TfNSW reference: WST24/0047/005

DPHI reference: SSD-67478479

SSD-67478479 – Yanco BESS – Lot 516, 512, DP 751745, 120 Houghton Road, Yanco – Response to EIS

Attachment 1

Figure 1 | Proposed site access

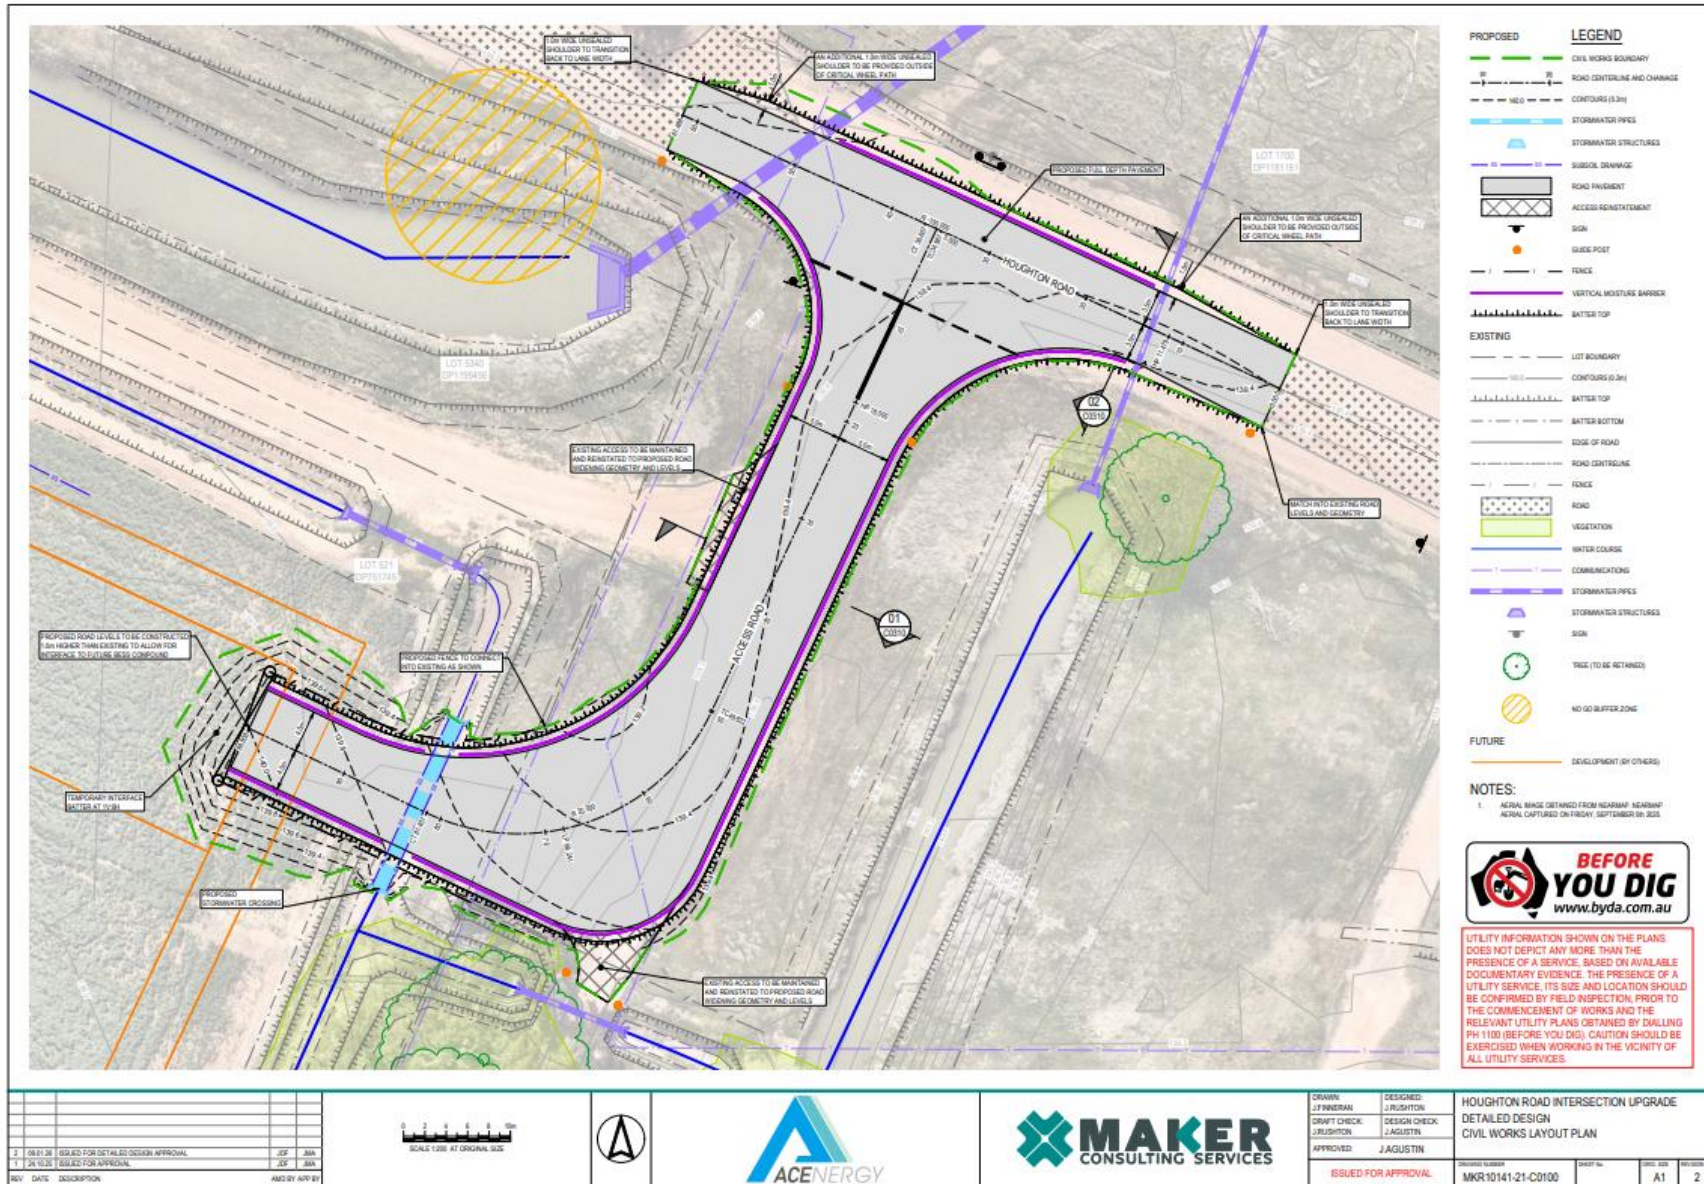
- d) Considering point 2(c), updated swept paths are required for the design vehicle demonstrating concurrent turn movements in all directions.
- e) Applicant is to consider the potential risks of installing a rural basic right turn (BAR) treatment at Houghton Road close to the access to Yanco rural Fire Station driveway and the railway line.

Figure 2 | Irrigation Way / Houghton Road intersection upgrades

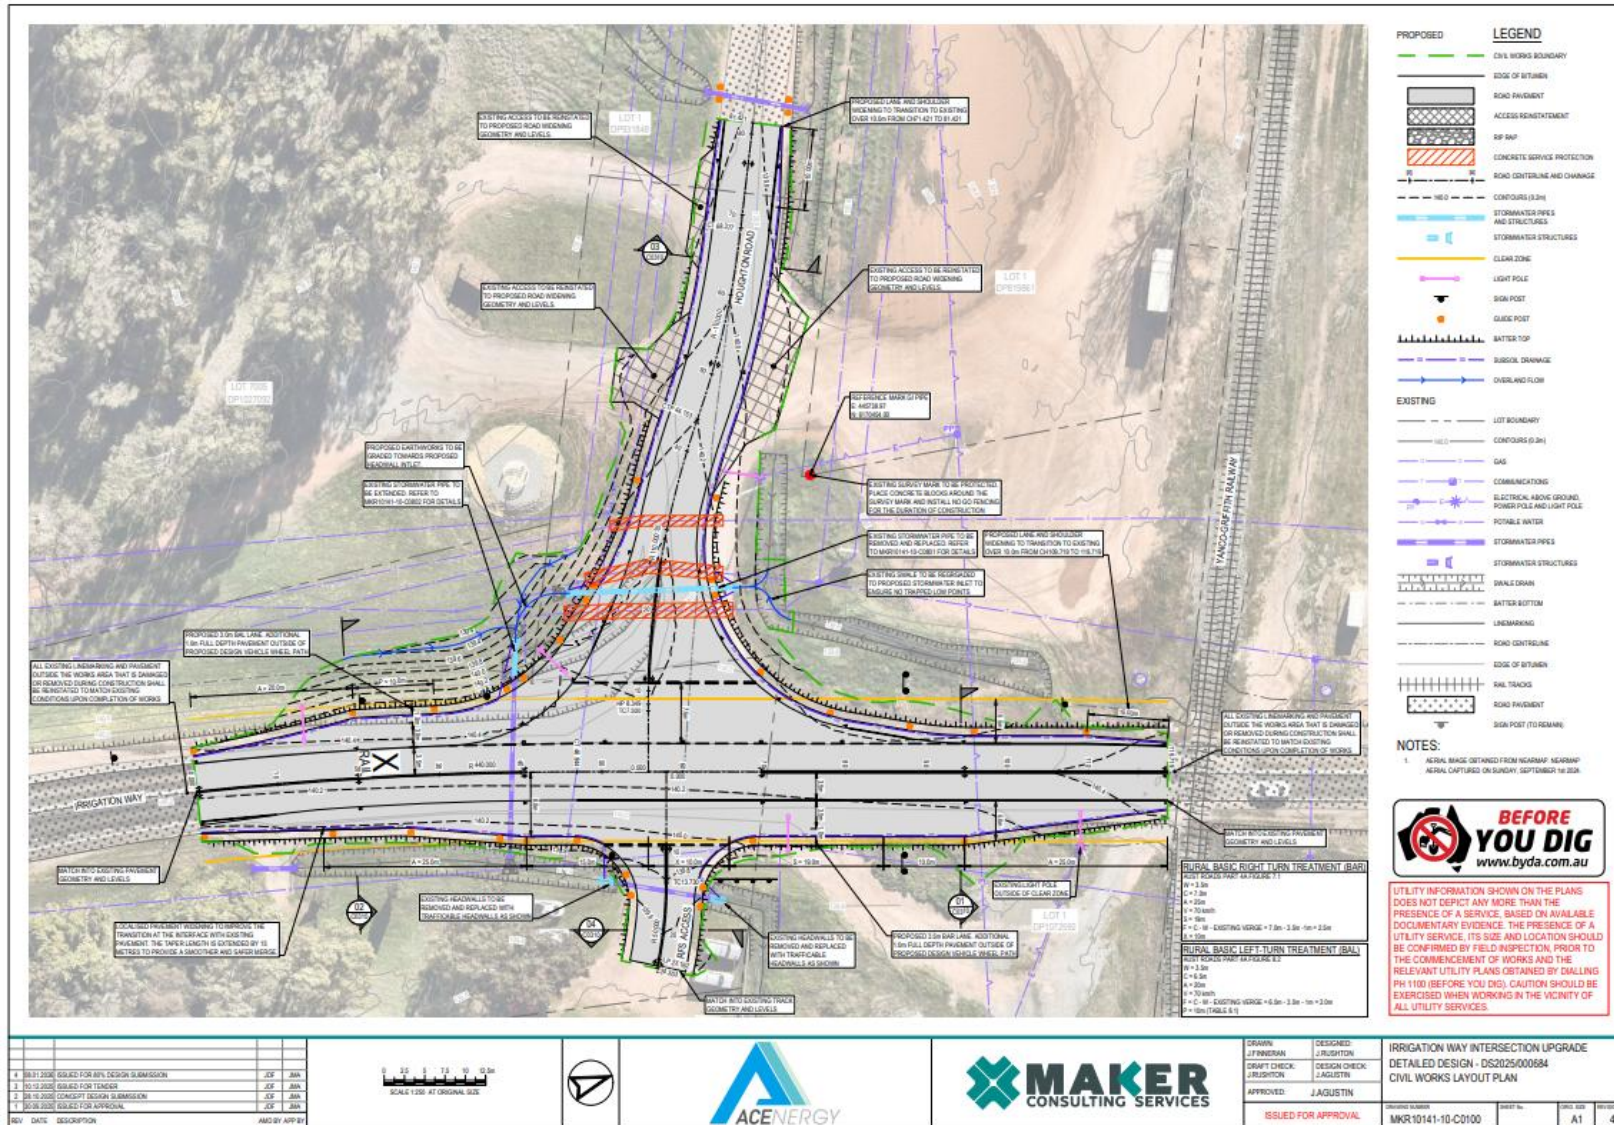
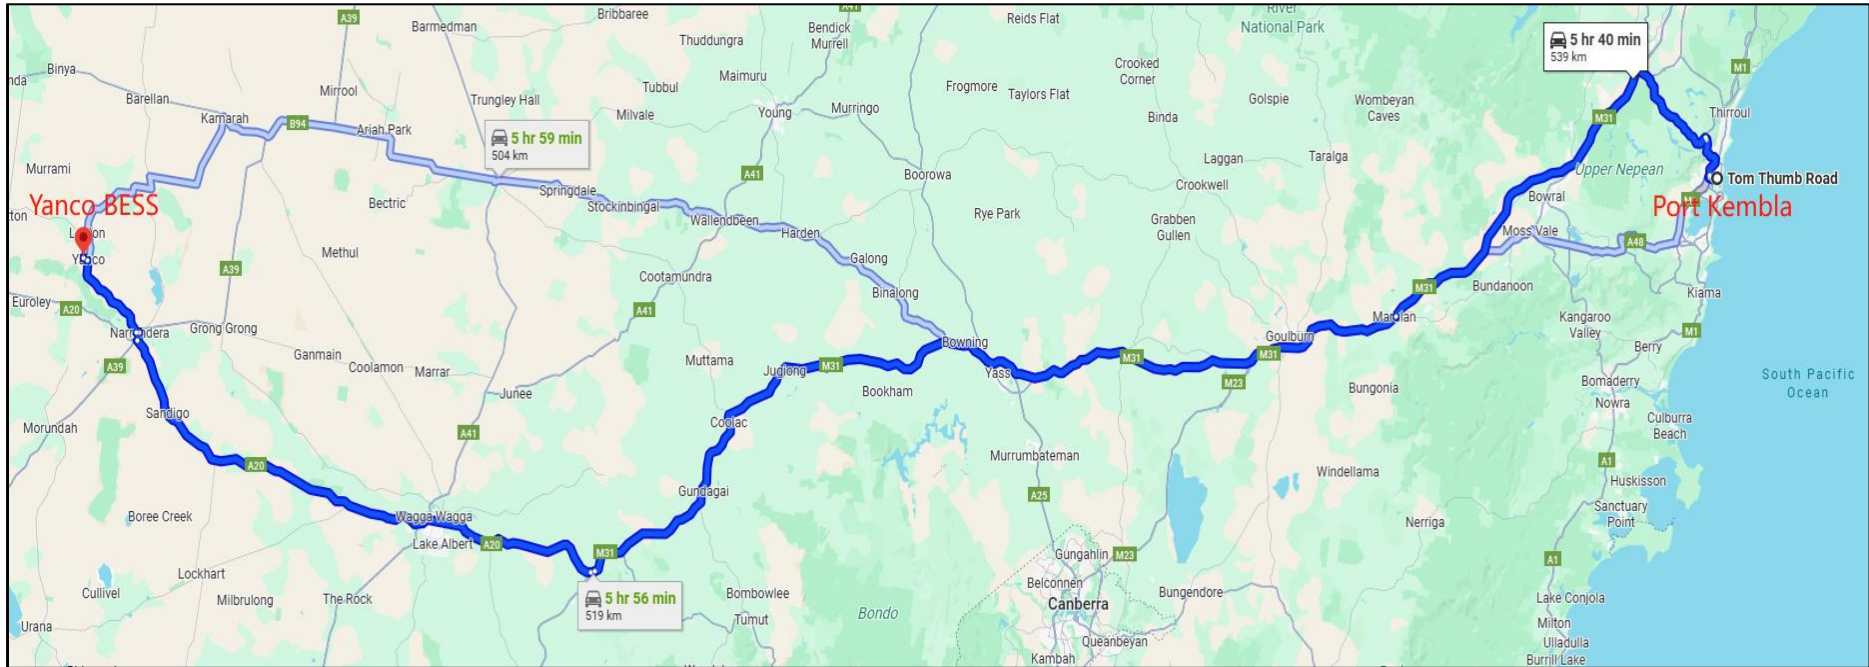
- a) Houghton Road/Irrigation Way rural basic right turn (BAR) A values appear to have been designed for the posted speed of 60 km/h. It is TfNSW practice to design for 10km/h above posted speed limit. This would increase the A value to 22.5m.

- b) Houghton Road is a gazetted B-Double route to enable B-Doubles access to the GrainCorp Silos. The BAR S values should be rectified to allow for a 26m D Double not a 19m semi trailer.

- c) B-Double tracks on the chevroned median to complete the left turn out manoeuvre. A driver is likely to align their movement to the edge of the median and track further into the shoulder. This has the potential for heavy vehicles to track over the shoulder / verge interface and may result in edge break. TfNSW requests the shoulder be widened to accommodate this.

- f) Drainage detail must be provided on the strategic concept designs for intersections proposed to be widened. This includes a typical cross section. An example can be provided to understand the required detail if required. See attached fact sheet for more information:
